**Planning Department
Transportation Development Services**

October 7, 2015

Re: Taco Bell Renovations
4815 4th St., NW
Traffic Circulation Layout
Engineer's/Architect's Stamp dated 9-4-15 (F14-D071)

TCL-1

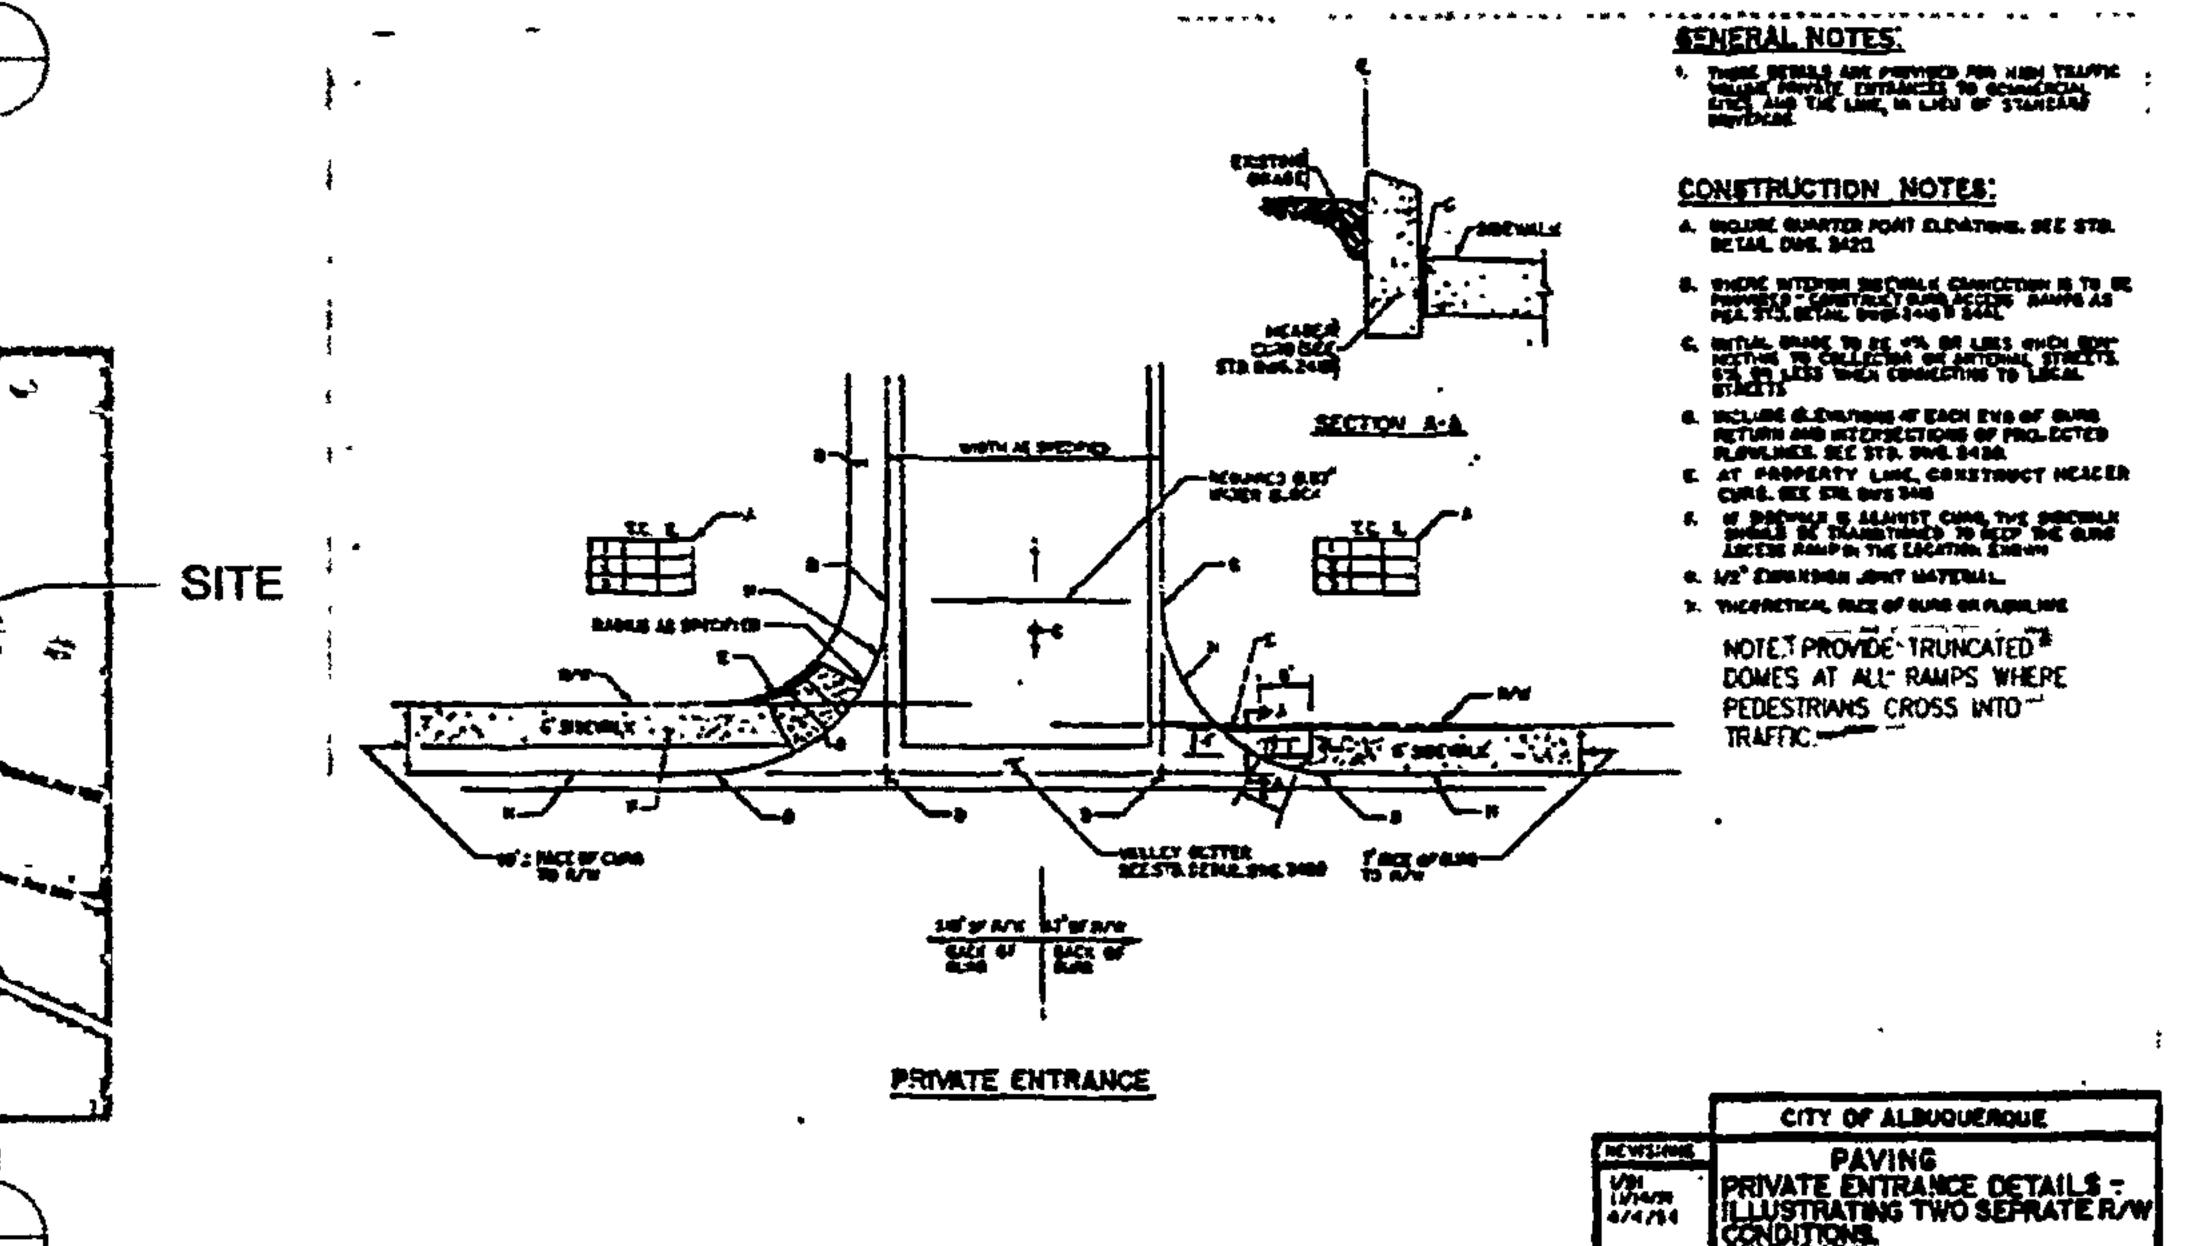
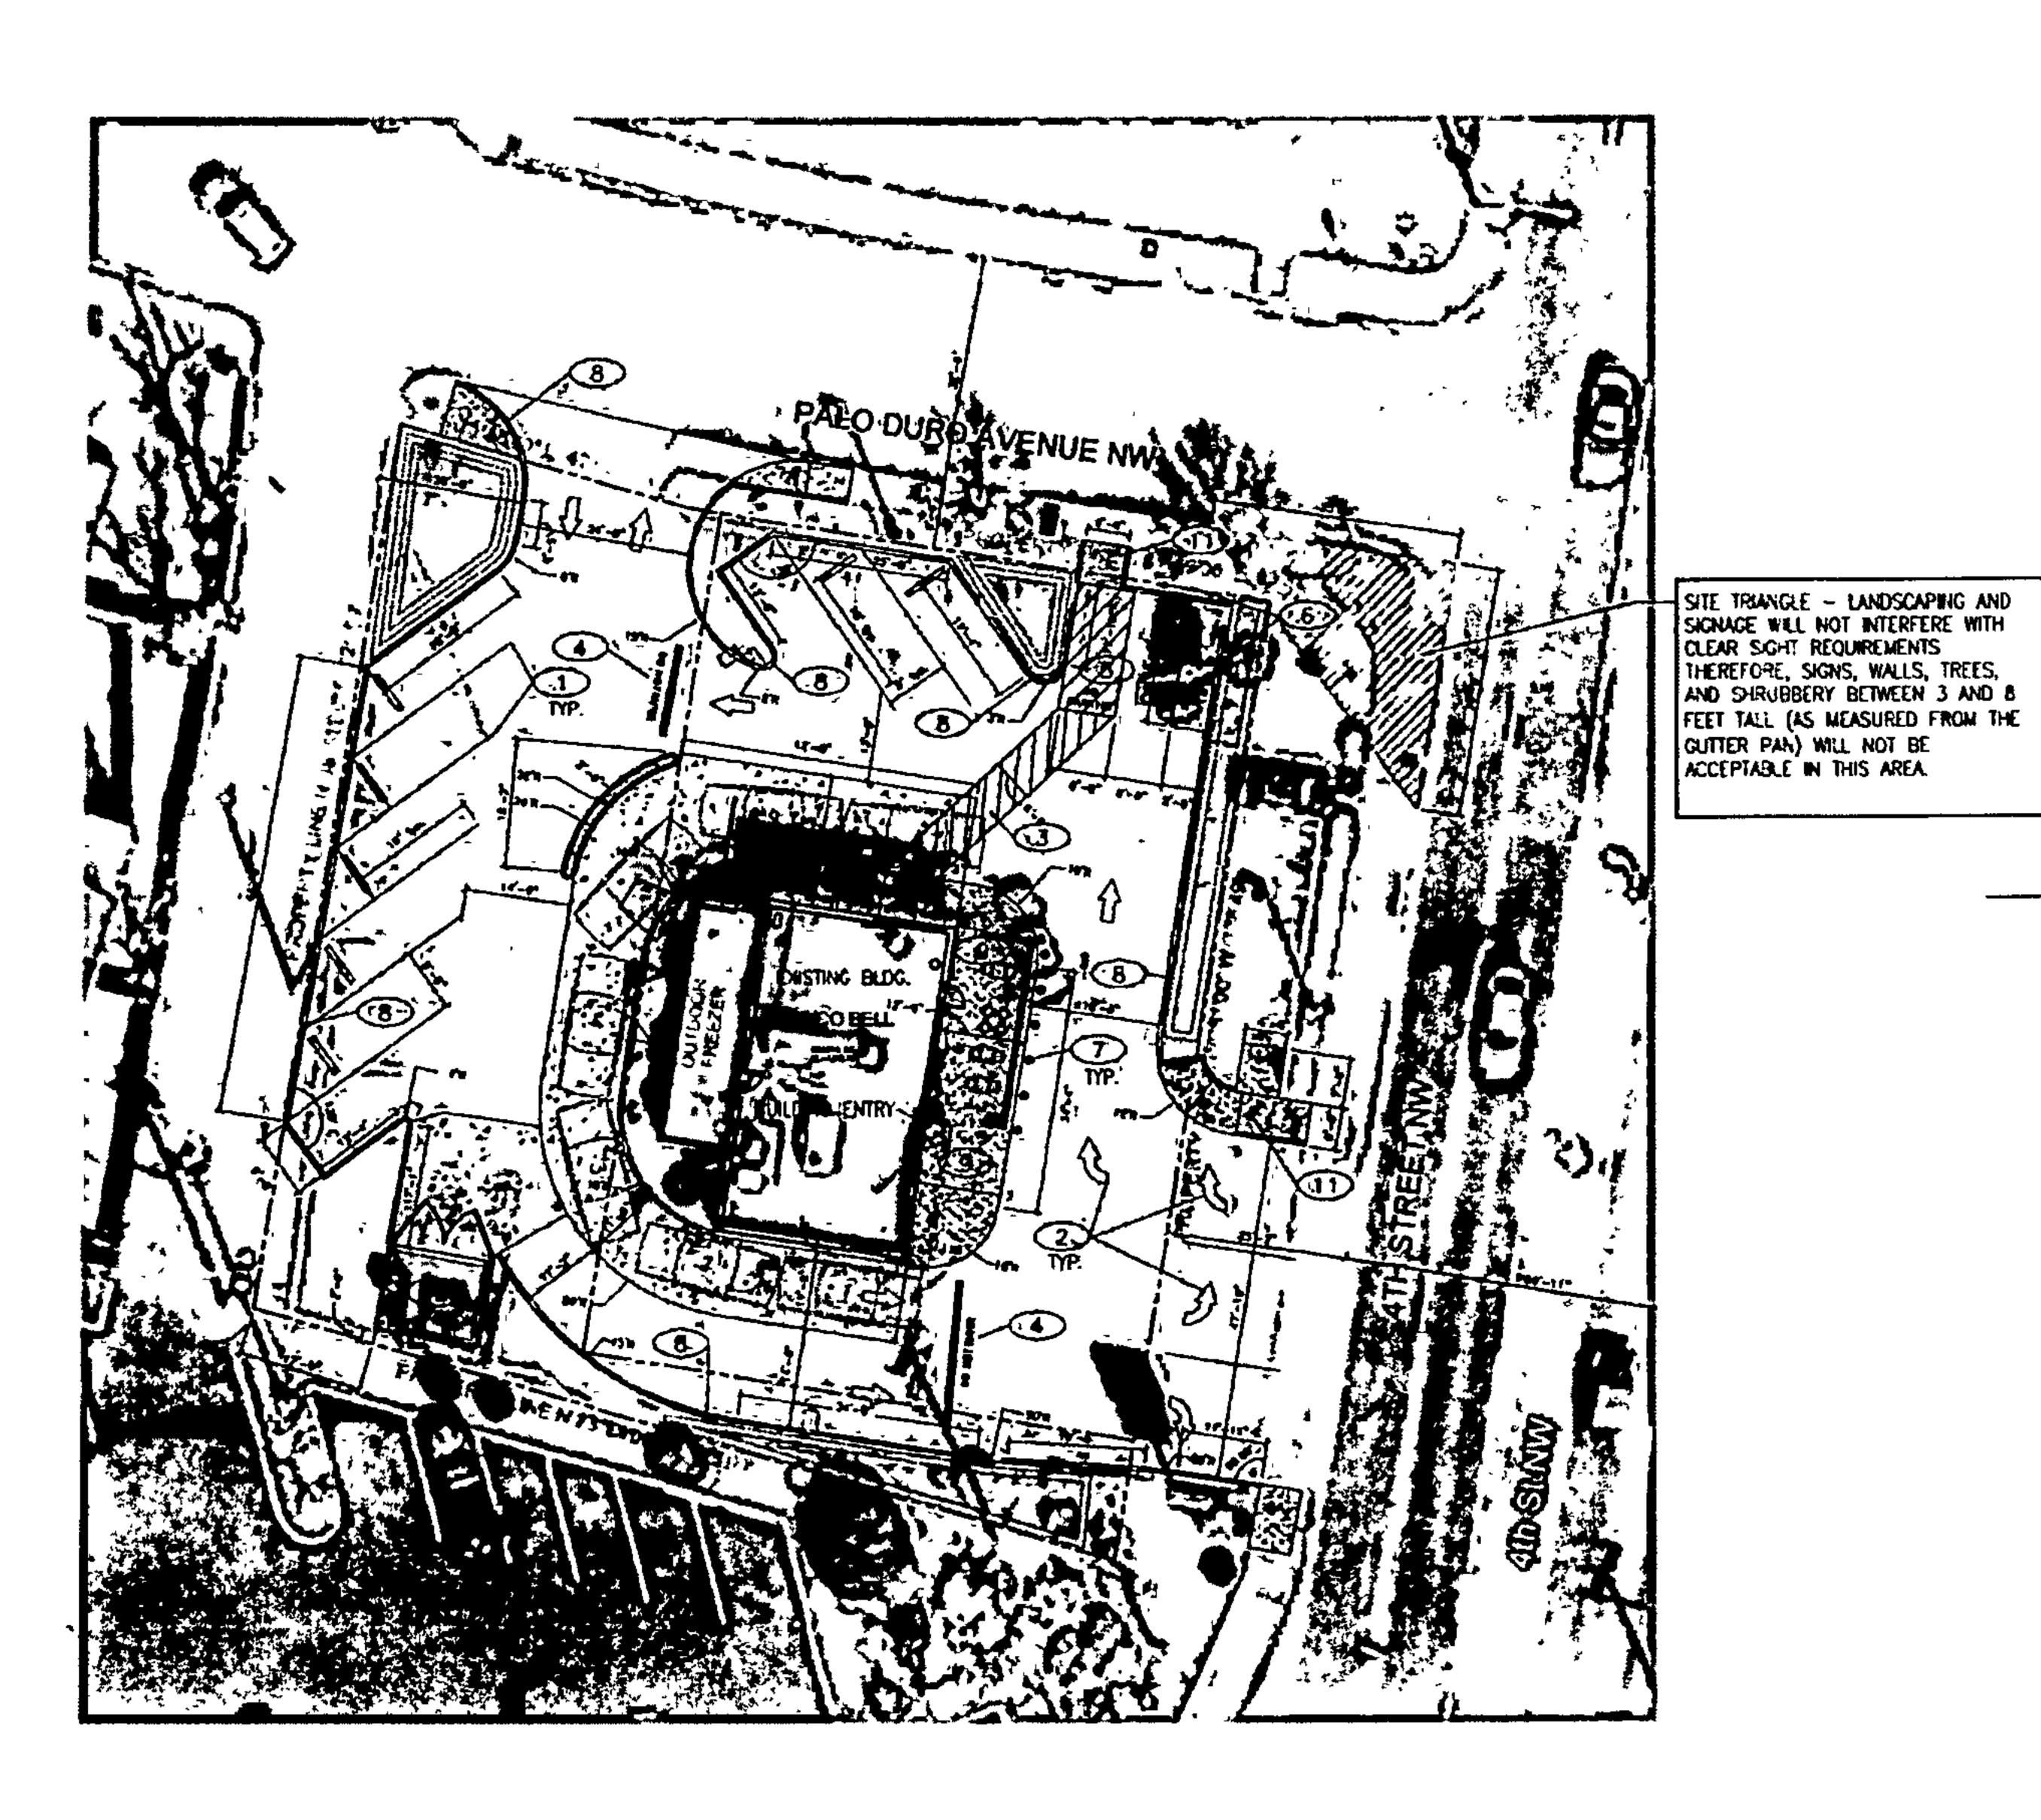
1. Please show a vicinity map showing the location of the development in relation to streets and well known landmarks.
2. List the number of parking spaces required by the zoning code as well as the proposed number of parking spaces. Please include the number of required handicap parking spaces.

3. Please identify all existing buildings, doors, structures, sidewalks, curbs, drive pads, walls and anything that influences the parking and circulation on the site.

4. Identify all existing access easements and rights of way with dimensions.
5. Identify the right of way width, medians, curb cuts, and street widths on 4th St. and Palo Duro Ave.

6. Please list the width and length for all parking spaces. Detail the overall length of all the diagonal parking spaces and overall drive isle widths.

7. Please detail the drive thru queuing length.
8. The handicap accessible spaces must include an 8-foot wide van access aisle; all other aisles should be 5 feet in width.

9. The ADA accessible parking sign must have the required language per 66-7-352.4C NMSA 1978 **"Violators Are Subject to a Fine and/or Towing."**
10. The ADA access aisle shall have the words **"NO PARKING"** in capital letters, each of which shall be at least one foot high and at least two inches wide, placed at the rear of the parking space so as to be close to where an adjacent vehicle's rear tire would be placed. (66-1-4.1.B NMSA 1978)

11. Per the DPM, a 6 ft. wide ADA accessible pedestrian pathway is required from the public sidewalk to the building entrances. Please clearly show this pathway and provide details from both 4th St. and Palo Duro Ave.
12. Per the DPM, a 6 ft. wide ADA accessible pedestrian pathway is required from the HC parking stall access aisles to the building entrances. Please clearly show this pathway from the handicap parking space.
13. Service vehicle and/or refuse vehicle maneuvering must be contained on-site; provide a copy of refuse approval.
14. Please provide a sight distance exhibit (see the *Development Process Manual, Chapter 23, Section 3, Part D.5 Intersection Sight Distance*) for both 4th St. and Palo Duro Ave.

15. Please add the following note to the clear sight triangle: "Landscaping and signage will not interfere with clear sight requirements. Therefore, signs, walls, trees, and shrubbery between 3 and 8 feet tall (as measured from the gutter pan) will not be acceptable in this area."
16. Please include two copies of the traffic circulation layout at the next submittal.
